## Heckington Fen Solar Park

EN010123

### Appendix 16 Statutory Consultation – Written Responses under Section 42 of the Act & How Ecotricity responded

Document Reference: 5.1.16

Drawing file: EN010123 / EN010123-000203-6.2.4 - Figure 4.1e Proposed Ecological Enhancements for Operational Energy Park.pdf

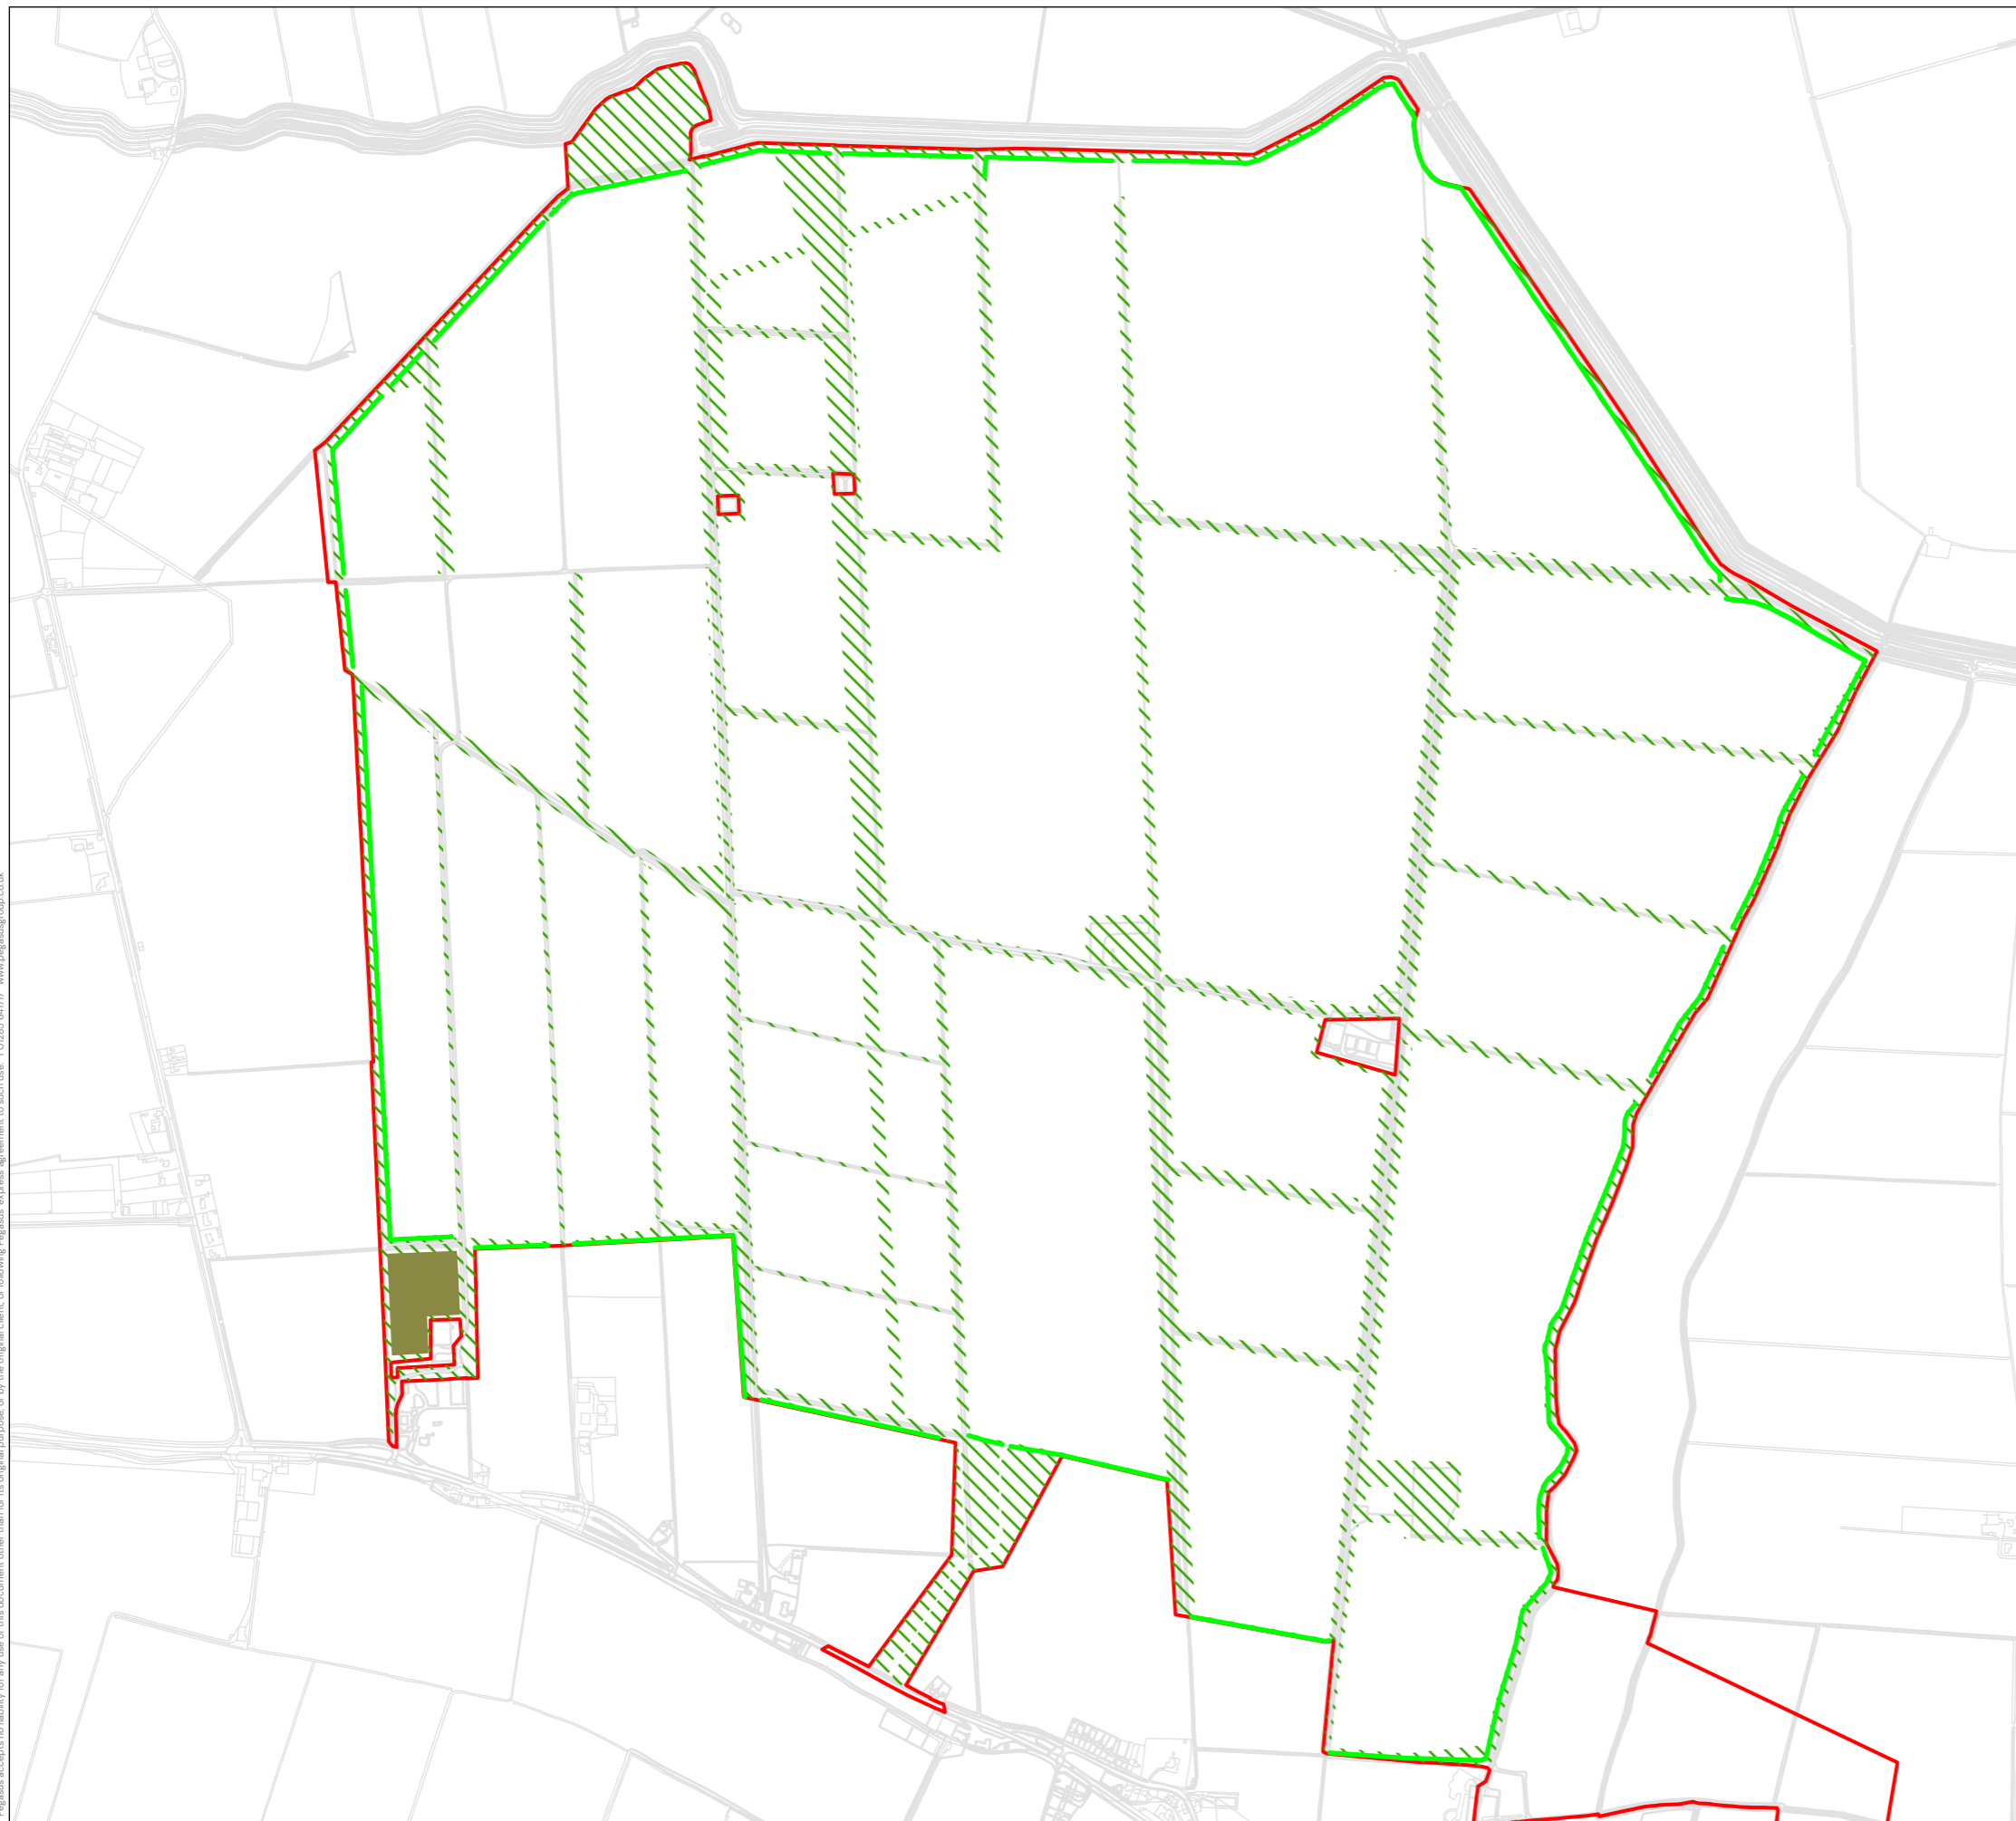
Issue Topic	Consultee	Date	Stakeholder Comment	Regard had by the Applicant
			Layout) and Figure 4.1e (Proposed Ecological Enhancements for Operational Energy Park) identify different sized areas for potential biodiversity net gain with one identifying this as 95.34ha and the other citing 112.15ha. This should be clarified for consistency reasons.	the time of writing. The layout has subsequently been updated for the ES (document reference 6.1.1).
Chapter 4, Proposed Development	North Kesteven District Council	1 September 2022	<p><u>4.5.26 to 4.5.28</u>  Noted increase in numbers; how do the substation locations (132kv/400kv) align with the ALC grades and the consideration of alternatives (layout) mindful that impacts associated with the substations and associated hardstanding are elevated?</p>	The Indicative Layout for this site has a single 400kv substation located within the ESS area. The ESS has been located on Grade 3b land. A plan within the DAS shows this information.
